Planning Application: Seeking advice on a full planning application for the sub division of the existing plot to add two new detached properties with separate access and detached garaging.

Reference: R/91/17/PL

Location: The Spires, Springfield Close, East Preston

Consultant Arboriculturist

2 PROPOSED NEW HOUSES ~ PLOT 2 TO THE NORTH OF AT "THE SPIRES" SPRINGFIELD CLOSE EAST PRESTON

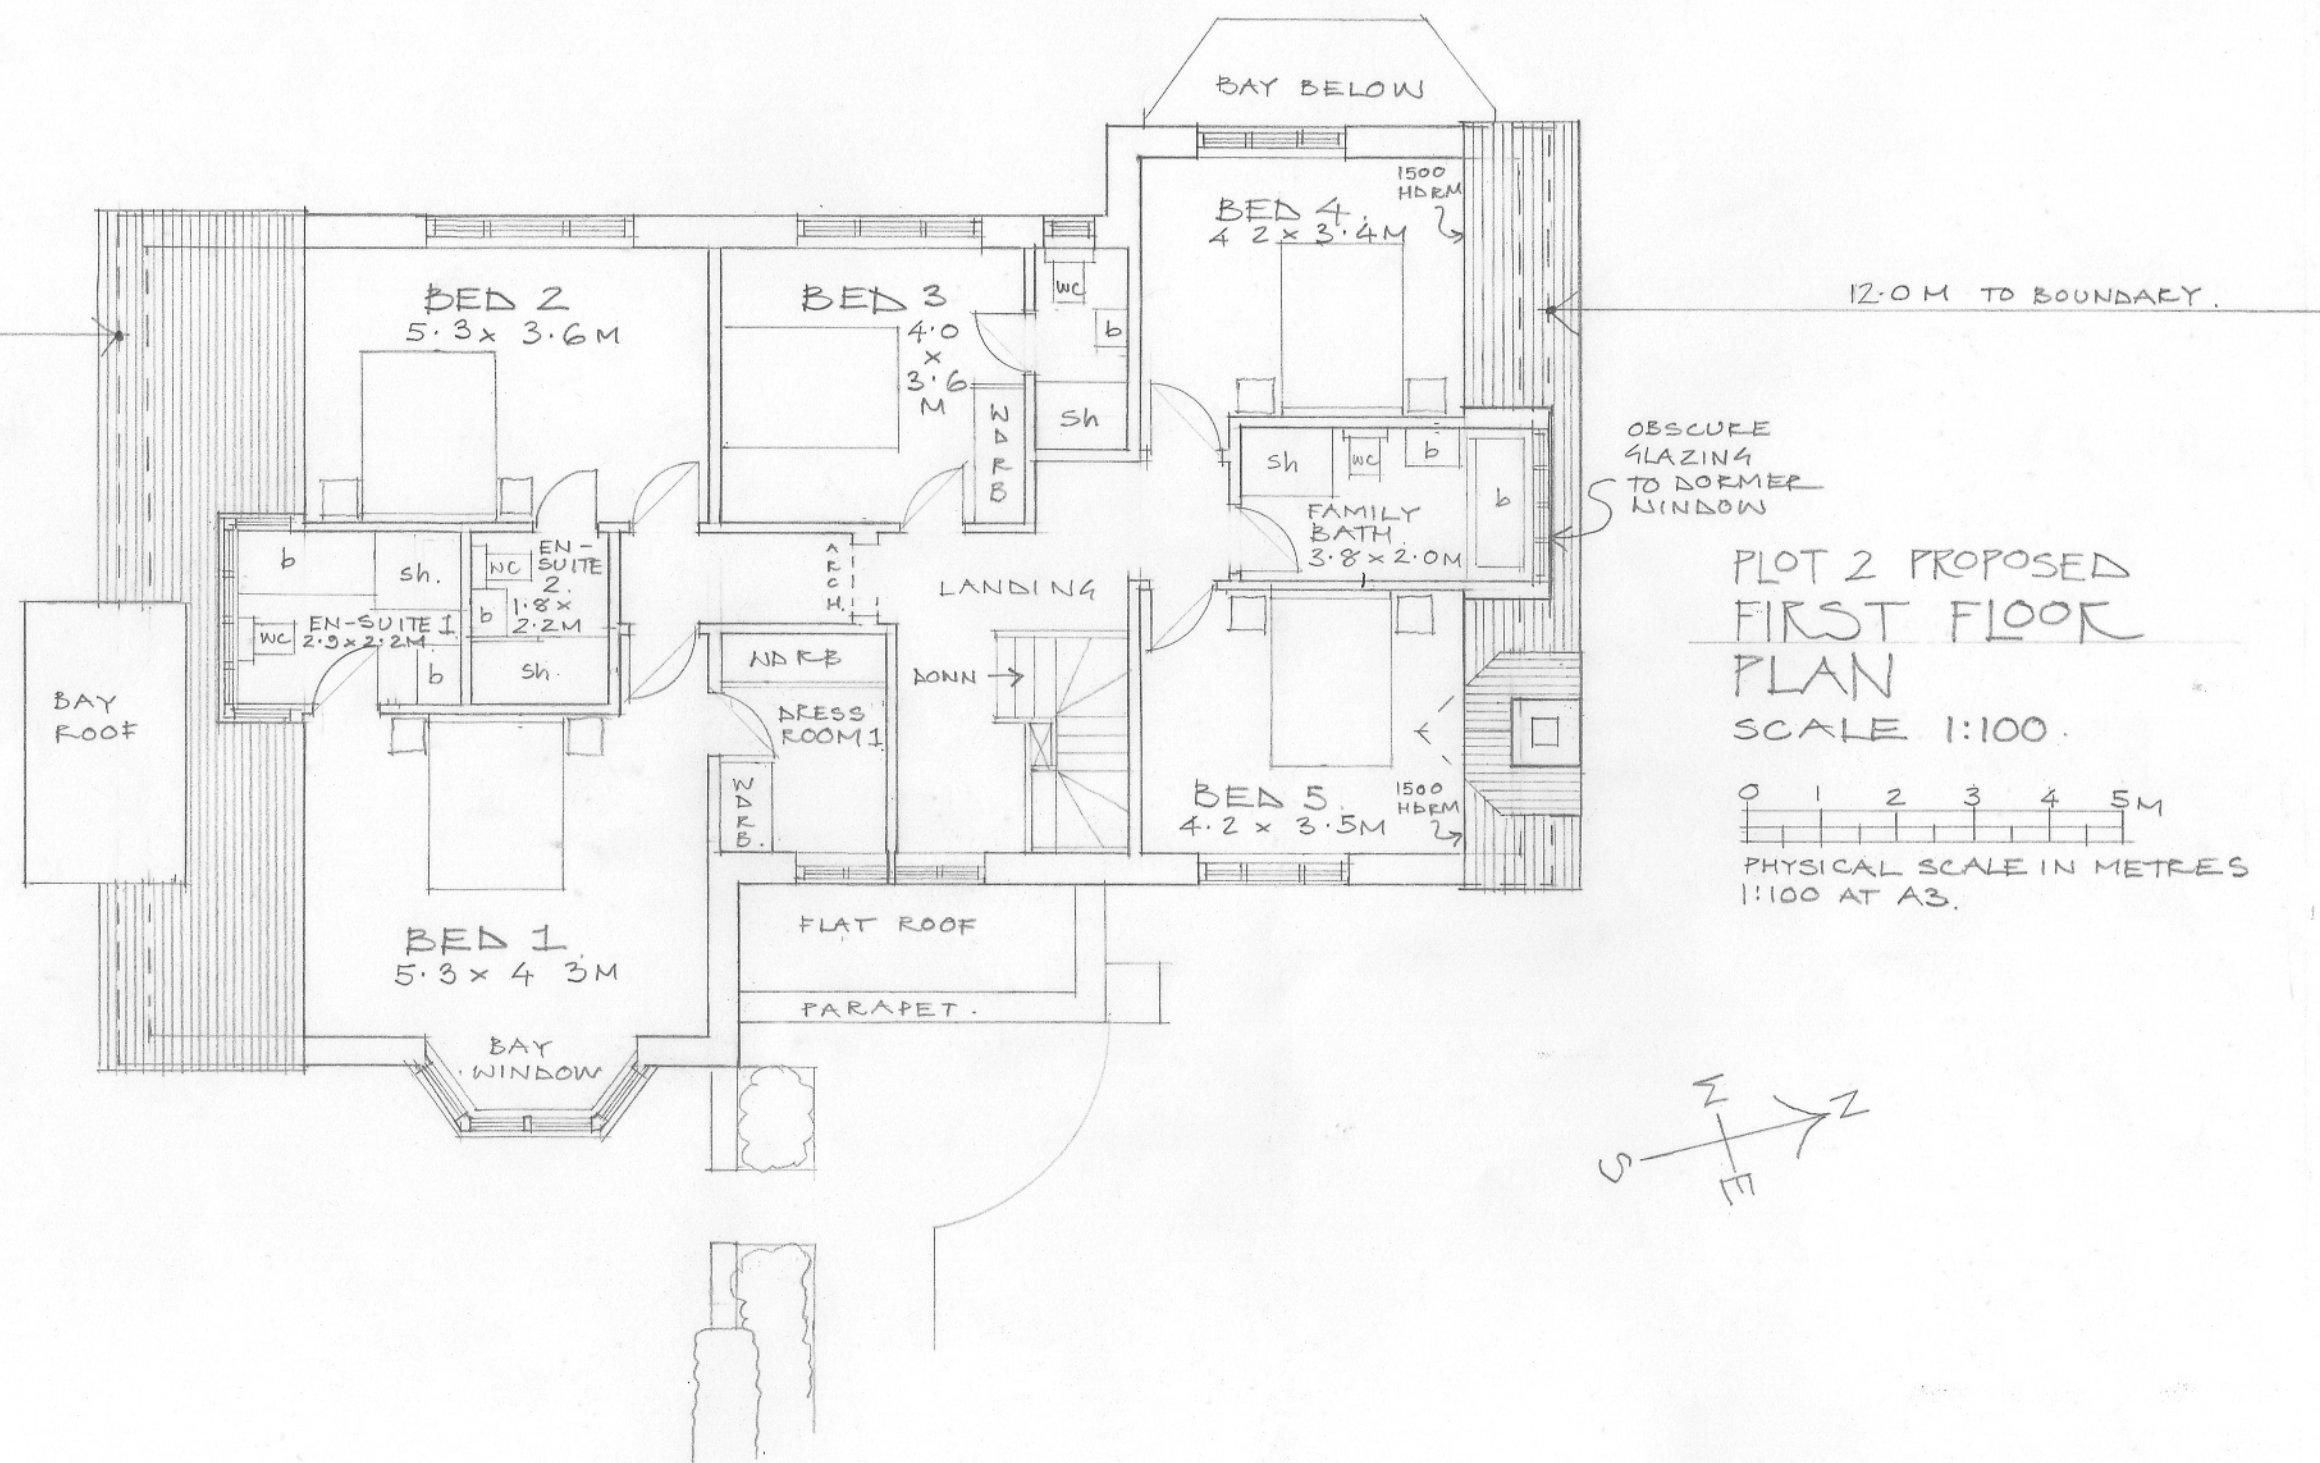
- The relationship of the Northern Dwelling to the huge mature TPO'd Poplar gives rise for concern both for the requirement for adequate foundations to resist root action but also for the overbearing nature of the canopy and the intense shade it will cast notwithstanding the fact that this tree has extensive amounts of surface rooting which will be damaged by the proposals.

Tree Retention and Protection Plan

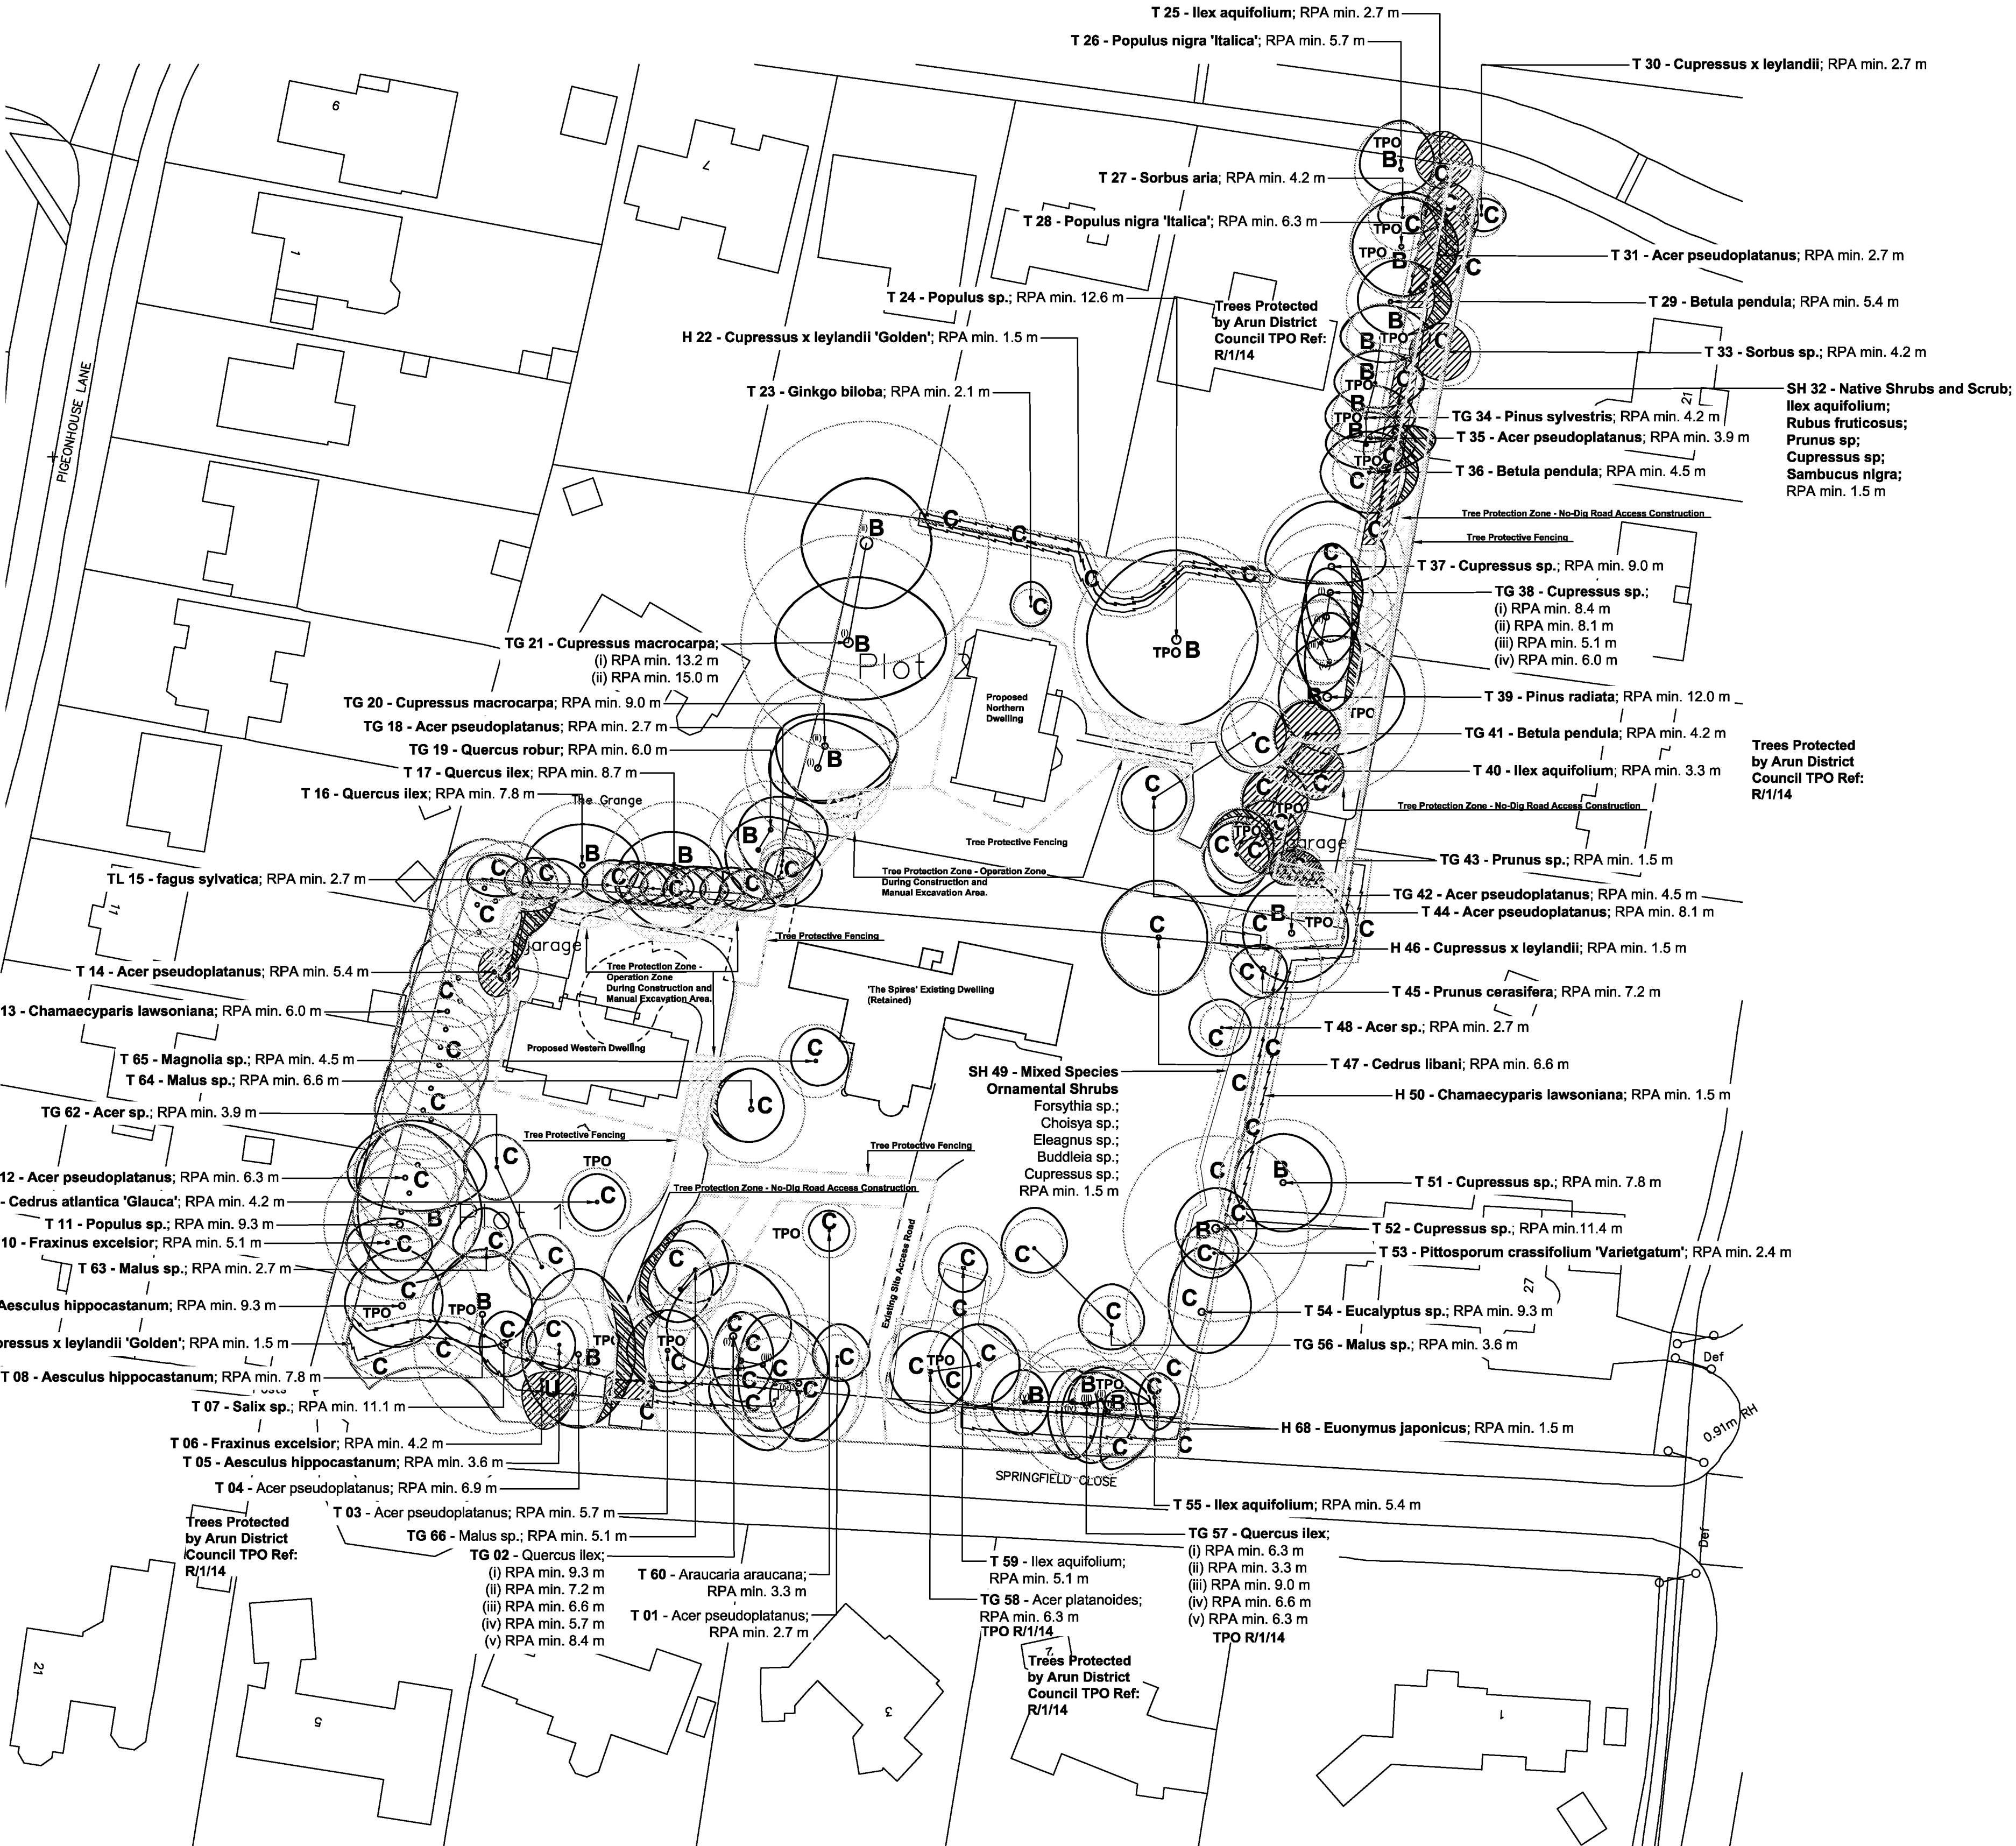
- The applicants have employed **Lizard Landscape Consultancy** to carry out a tree survey and then prepare an Assessment of the impact that development will have on the existing tree stock a lot of which is TPO'd.
- A Method Statement Report has been provided to explain how the 'No Dig' access roads will be installed without adversely impacting on retained trees.
- However, In my opinion the proposals have the potential to adversely affect a number of TPO'd trees positioned both on and off the site.

- Whilst I do not object to the principle of redeveloping this site I do have concerns as to the tree protection measures which are being proposed.
- I also have concerns over the two new access points both of which require extensive amounts of 'No Dig' cellular confinement to be laid and there is no cross section drawings or details of how this will tie in with existing levels.

- With regards to the western dwelling this will require significant crown lifting work to make this access viable and this will change the whole character of the tree line which is TPO'd and of significant visual amenity value.

- I **OBJECT** to this scheme on the grounds that it threatens the future safe retention of TPO'd trees.
